Application for a non-material amendment following a grant of planning permission.

Number	91
Suffix	
Property name	
Address line 1	The Fairway
Address line 2	
Address line 3	
Town/city	Aldwick
Postcode	PO21 4EW
Description of site location must be completed if postcode is not known:	
Easting (x)	490250
Northing (y)	98085
Description

Ground floor and 1st floor rear extensions. This application affects the character and appearance of the Aldwick Bay Conservation Area.

AW/279/15/HH

ROOF PLAN PROPOSED 1:100

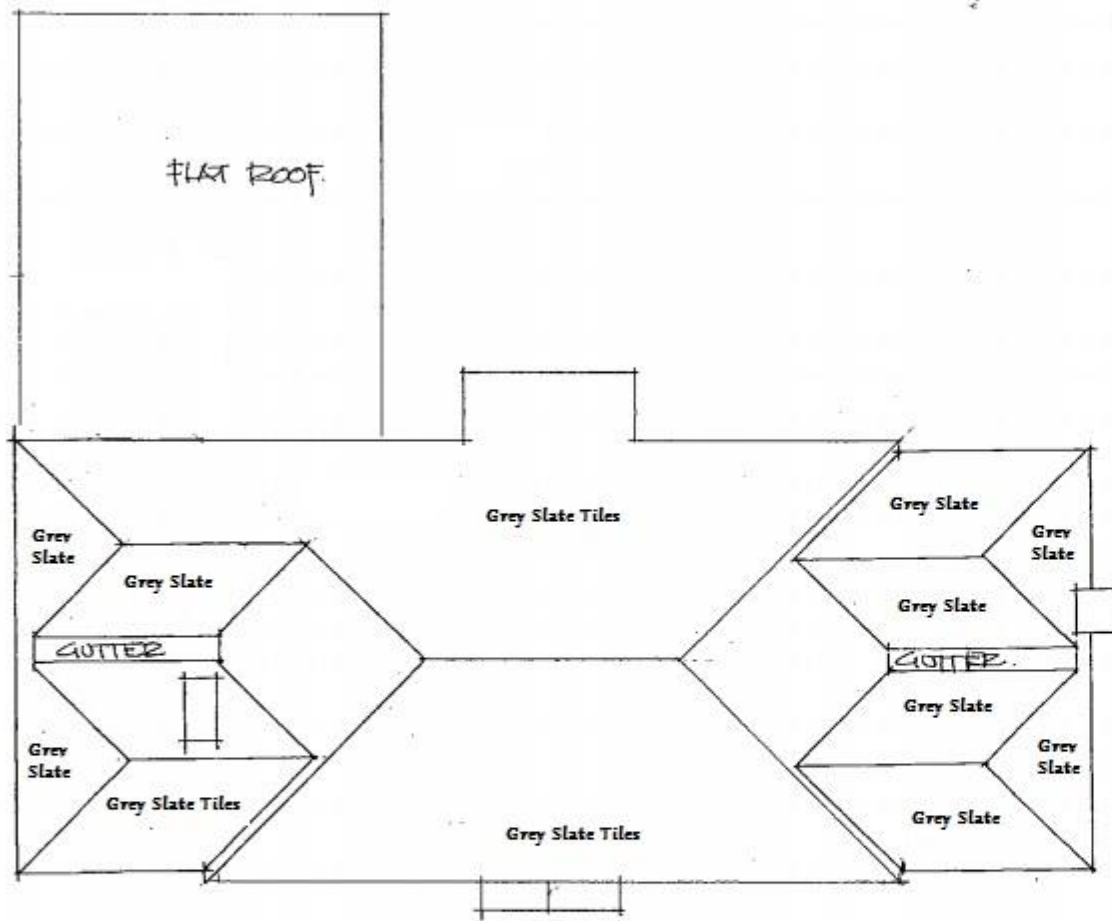
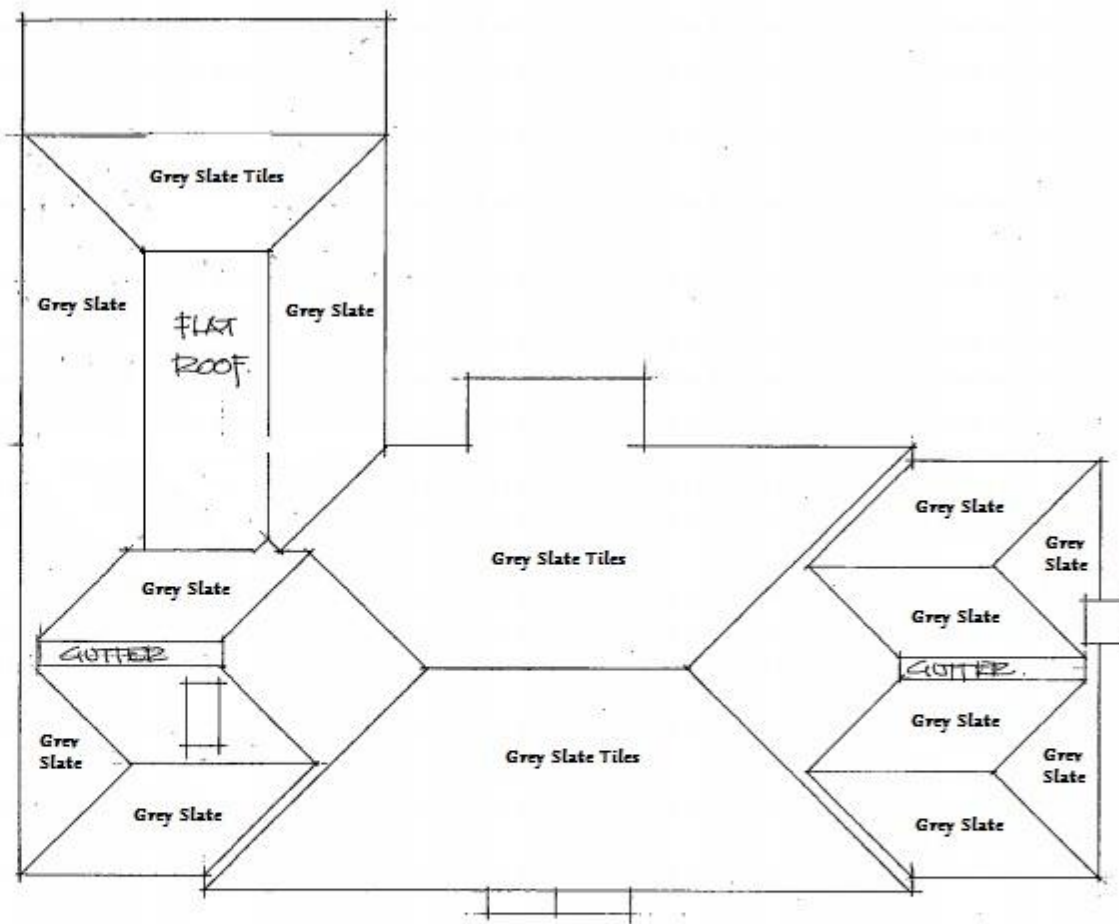
To change the 1'st floor gutter/roof line to match existing. The current/ approved plan is for the new master bedroom to be partly within the roof space. The amendment would give full ceiling height to the entire room. Please see attached drawings for full details including roof plan.

The amendment would give full ceiling height to the 1st floor bedroom. This amendment is also more "in keeping" with the rest of the building. A particular feature of the house is the moulded/plastered soffits. The amendment would make this feature possible, whereas on the original plan this was not an option.
